From: Fiona Fitzgerald
Sent: 01 August 2018 09:19
To: Planning.Responses
Cc: Zac Denton
Subject: LU/176/18/PD

Site Plan

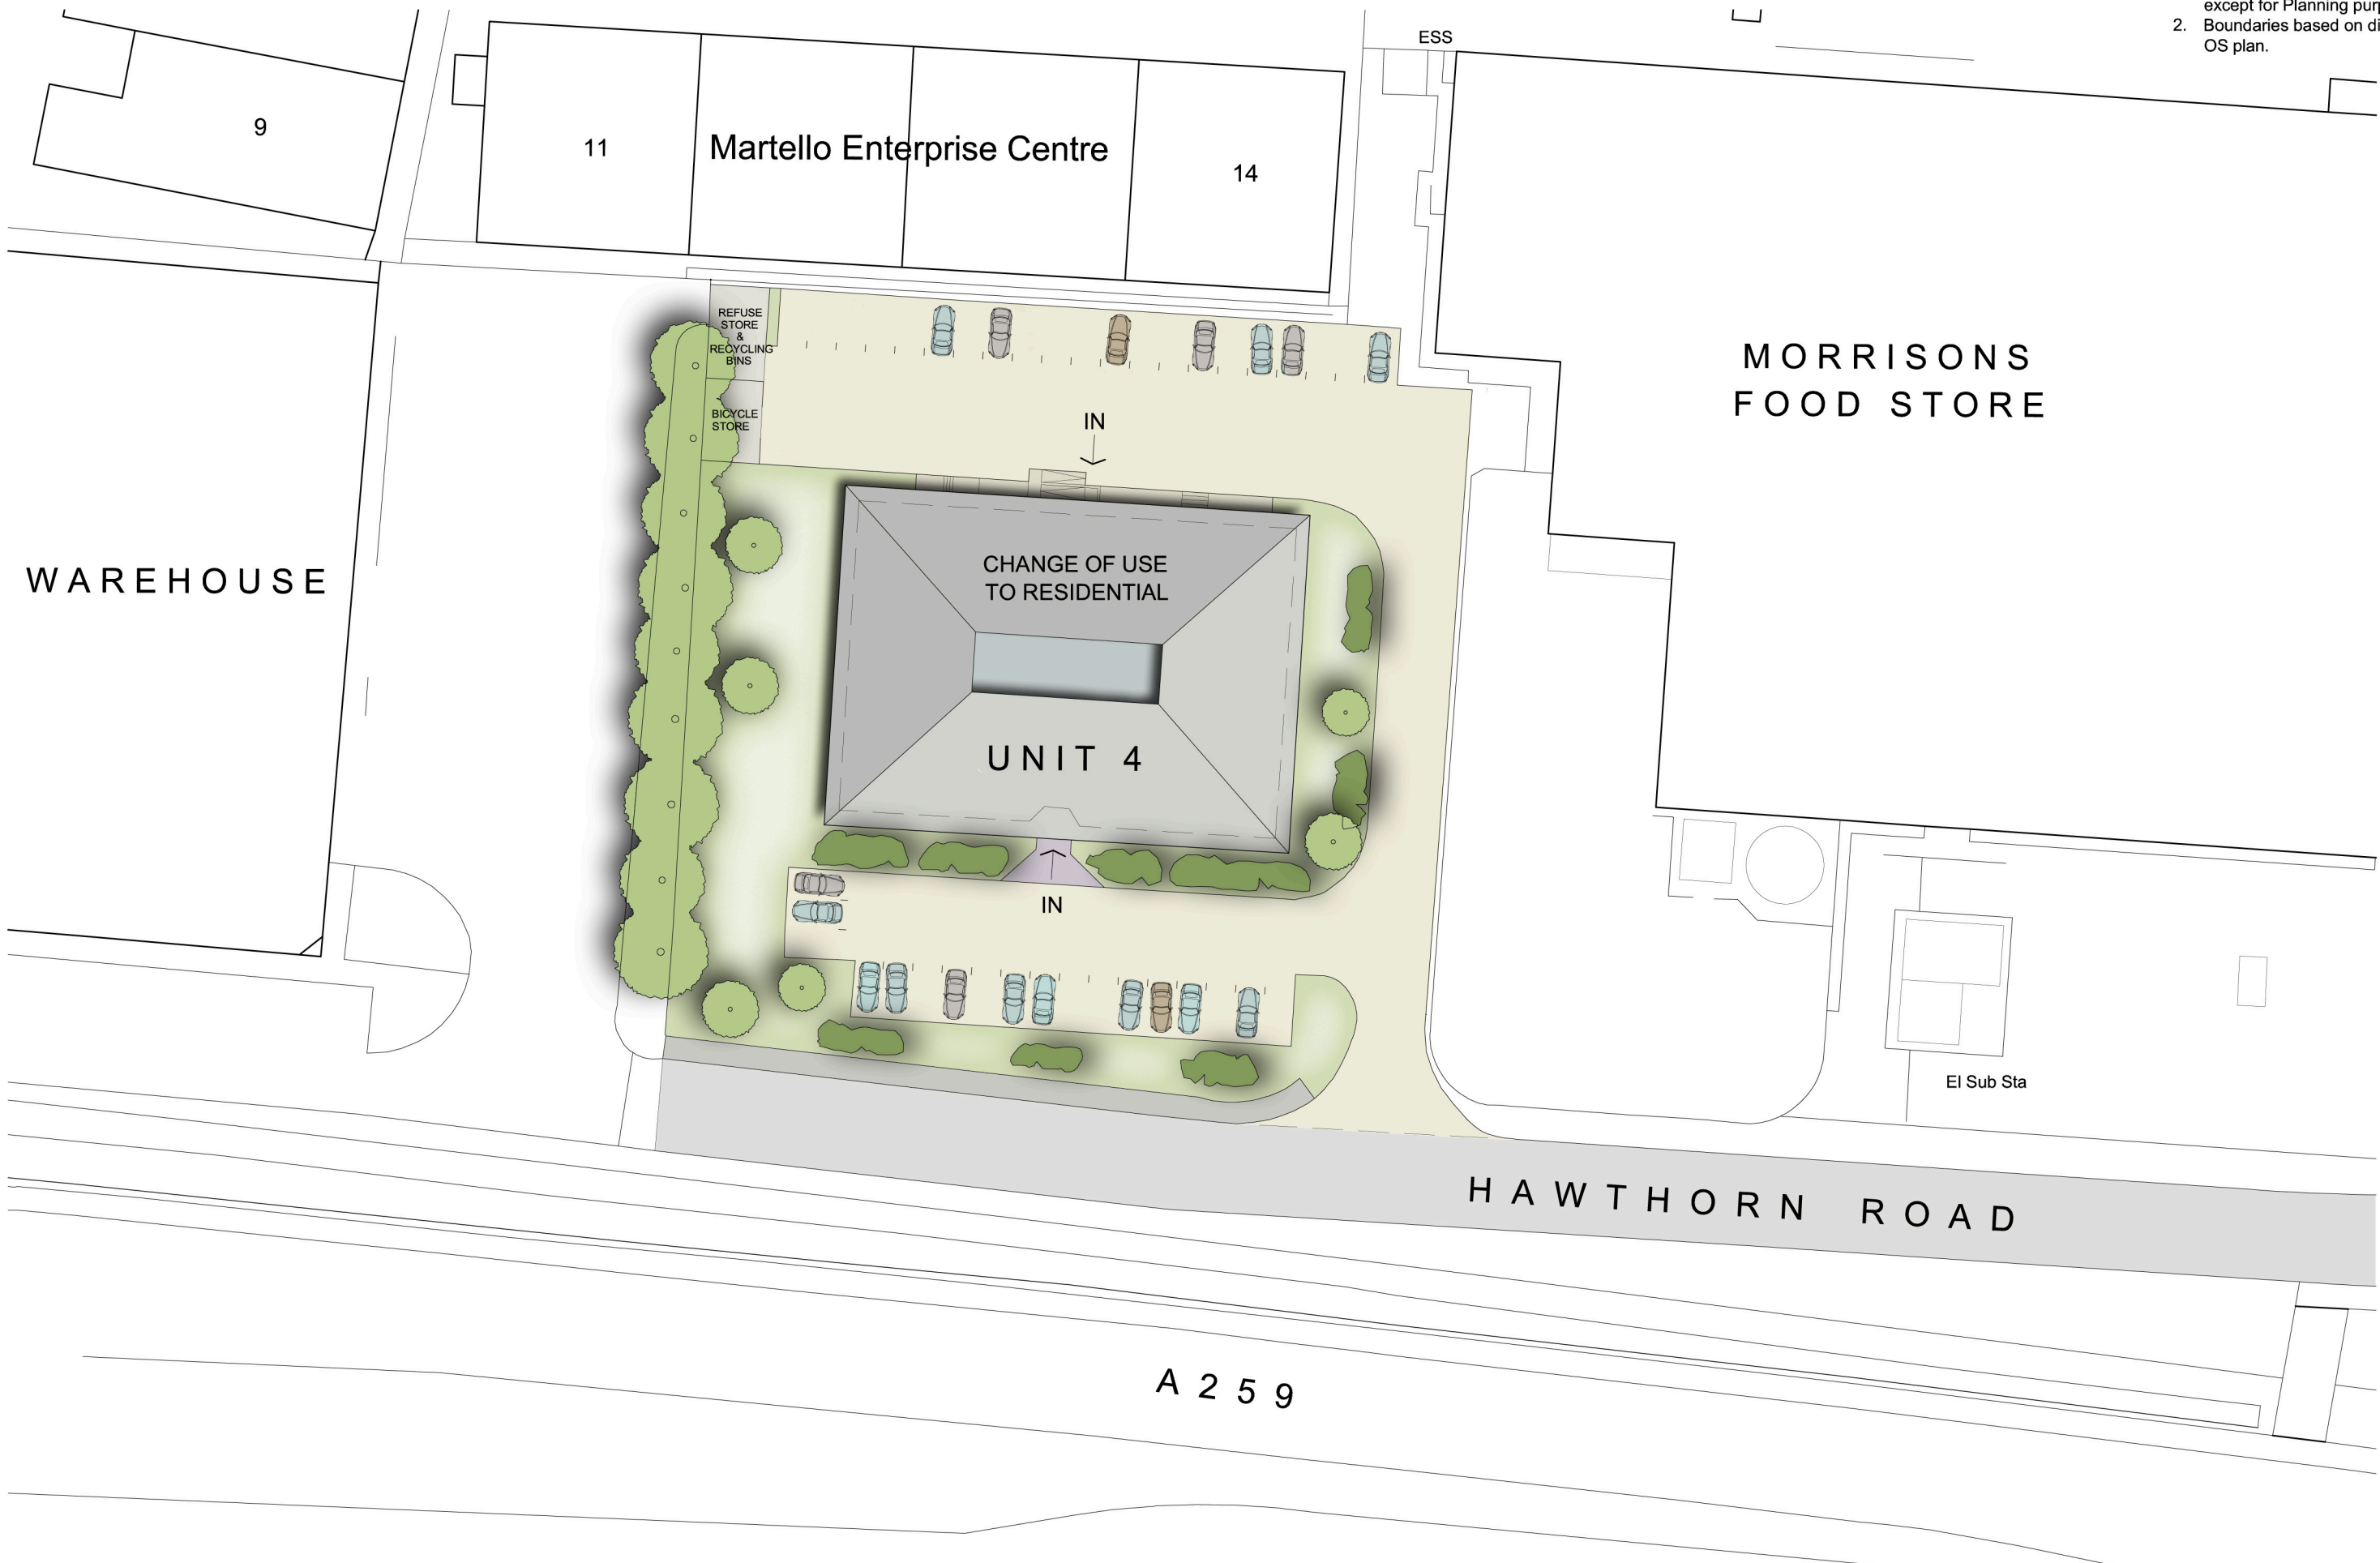
The application proposes to introduce noise sensitive receptors into an established area of commercial activity. Specifically there are commercial uses on the west, north and east sides, and the A259 on the south side of the proposed site. Noise from plant, machinery, deliveries, and ancillary activities from the surrounding commercial uses may adversely impact the amenity of future occupiers of the proposed development. Noise from the A259 may also adversely impact the amenity of future occupiers of the proposed development. No information on noise exposure is provided within the application.

The impacts on health and quality of life are such that this situation should be prevented from occurring. **I therefore recommend refusal.**
